**DECISION DELEGATED TO HEAD OF PLANNING**

**Application No:** H13-0058-25                      **Applicant:** Ms A Riley  
**Proposal:** Conversion of existing stable block to 2 self contained units to provide assisted living accommodation  
**Location:** Decoy Farm Fen Gate Moulton Chapel  
**Terminal Date:** 16th April 2025

The application seeks full planning permission for the conversion of an existing stable block into two self-contained units to provide assisted living accommodation.

FLOOR LAYOUT PLAN

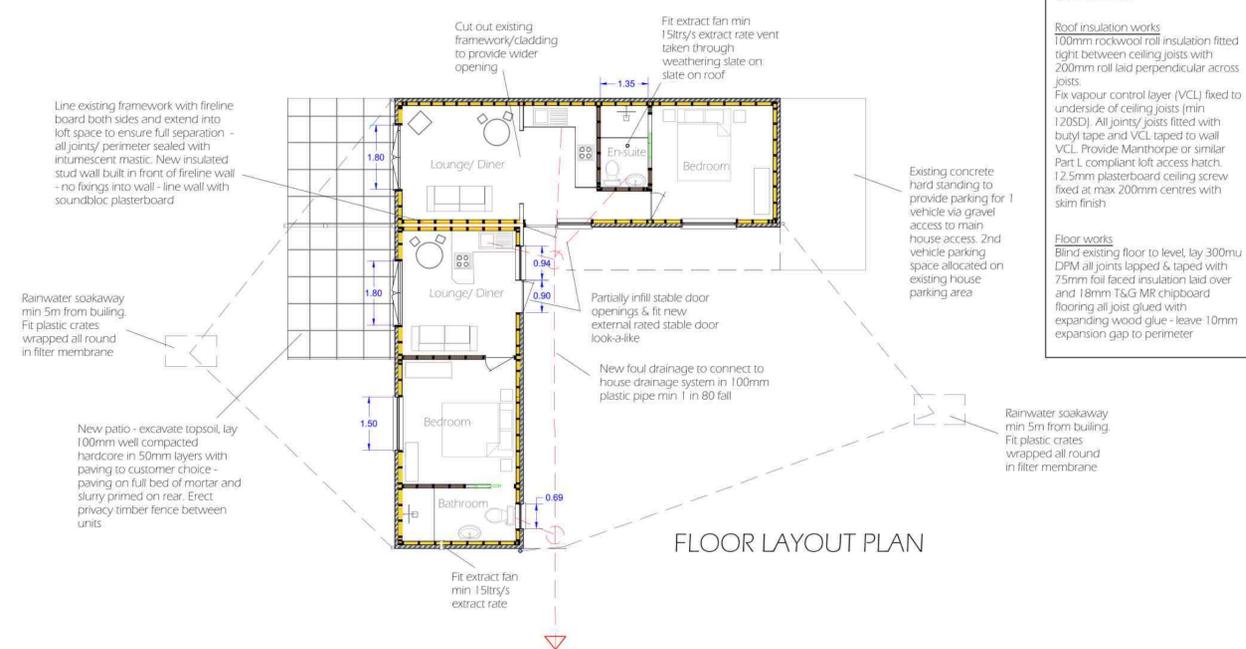
One of the proposed dwellings features approximately 33sqm of internal floorspace, and the other dwelling features approximately 27sqm. The nationally described space standard (NDSS) recommends that a minimum of 37sqm of floorspace is provided for a one-bedroom, one-person

dwelling with a shower room. Neither of the dwellings accords with this recommendation and it is considered that the proposed dwellings would not provide sufficient internal living space. This would result in a poor standard of living for future occupants. The applicant's agent has set out that the proposed dwellings would provide ancillary accommodation and that further living space would be provided within the main dwelling, which in this case is Decoy Farm. However, the application is for two independent dwellings, not ancillary accommodation and it is considered that there should be sufficient internal living space within the dwellings for occupants.

The proposed garden space for both dwellings is not demarcated on the submitted plans. Two patio areas are proposed next to each other next to the north-western elevation of the building. Whilst there could be room for amenity space within the site, this should be clarified within the submitted plans.

Parking spaces are not shown within the submitted plan for the two proposed dwellings. Whilst there is likely to be sufficient room for two parking spaces within the shared driveway for Decoy Farm to serve the two proposed dwellings, this is not clarified within the submitted plans. The parking spaces are also likely to be outside the red line boundary. Whilst Lincolnshire County Council's highways team have not raised any objections or recommended any conditions, the parking spaces should be proposed within the red line boundary for the site for clarity and to ensure they are proposed and retained for the future use of the occupants.
